From: Martyn White <Martyn.White@arun.gov.uk>
Sent: 19 February 2021 17:04
To: Raymond Cole <Raymond.Cole@arun.gov.uk>
Subject: BN/142/20/OUT

Land south of Barnham Station Barnham

Outline planning application with all matters reserved, other than principal means of access, for up to 200 No. dwellings, with access taken from Marshall Close, associated infrastructure & landscaping & demolition of existing buildings

Illustrative site layout plan

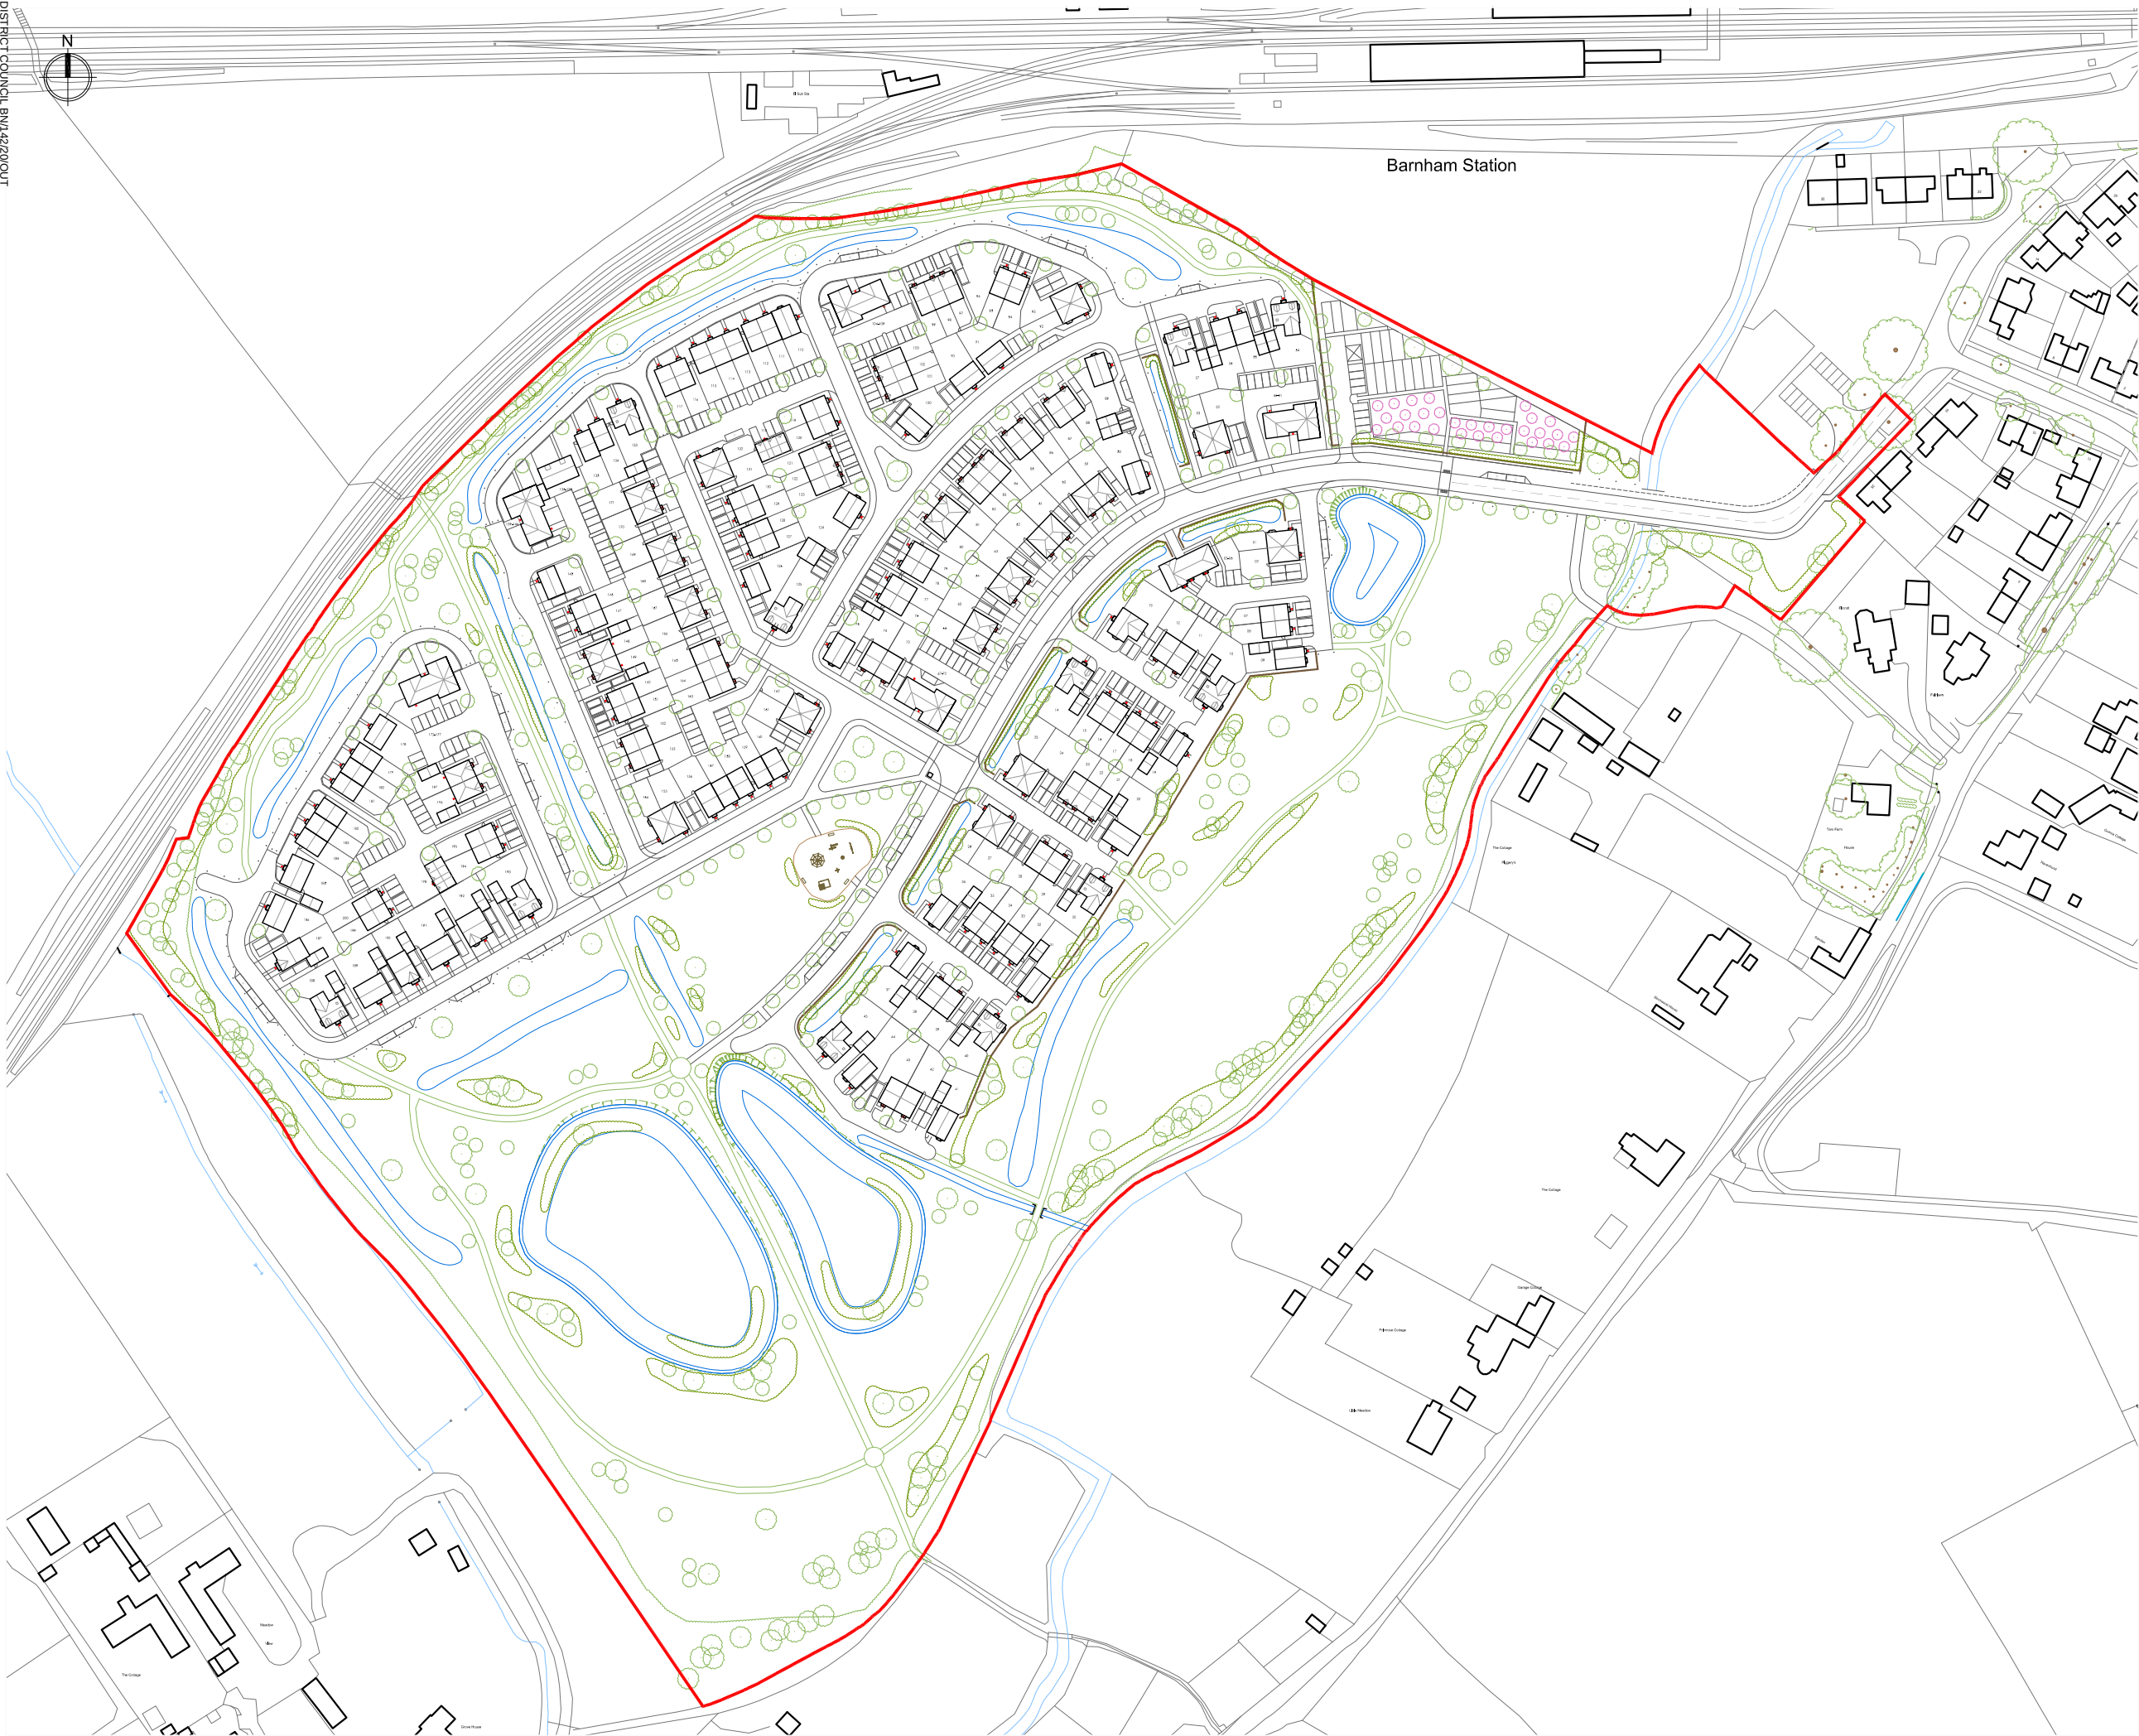
The proposal consists of 200 new homes, landscaping and infrastructure, with an access off Marshall Close. It appears from the illustrative landscape masterplan that the intention is for the open space to be located in the area closest to the Barnham Conservation Area (which also contains the majority of the heritage assets) as well as along the north-eastern boundary of the site. The latter being outside the conservation area, but the closest part to a number of properties in Church Lane.

The indicative layout indicates that there would be a large area of open space and landscaping as part of the development. This is in the area closest to the conservation area and could contribute towards softening the edge of the development. Although, this is dependent upon the level and type of screening and vegetation provided. However, it is considered that, in contrast to the existing views outward of buildings located beyond the mainline railway, the development as a whole would be closer and remain visible on the rising ground north of the stream.
